**Consultation Response from KC,
Lead Local Flood Authority**

2025/90033 adj, 916, Halifax Road, Hartshead Moor, Cleckheaton, BD19 6LR

Erection of 11 dwellings with access from Halifax Road and associated works.

Date Responded: 13/06/2025.

Technical Specification

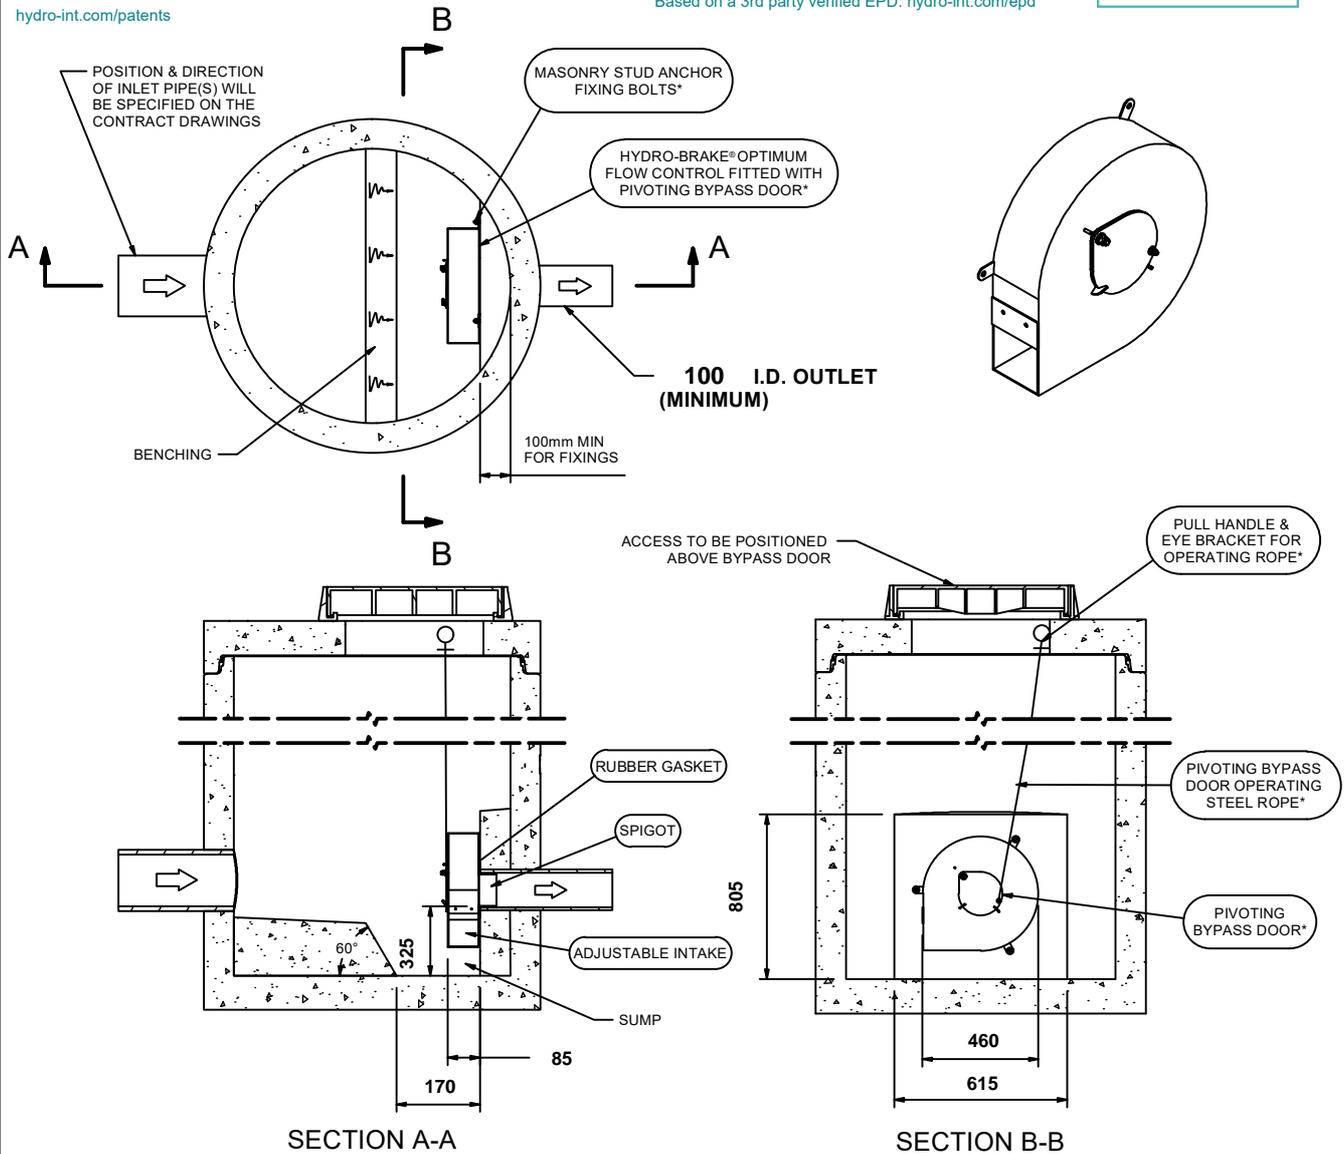
The diameter of the HydroBrake is given as 72mm in Appendix E of the Drainage Strategy, however the LLFA requires that the minimum diameter must be 75mm, therefore the HydroBrake design parameters will need to be adjusted to suit, and new calculations provided using a compliant HydroBrake design.
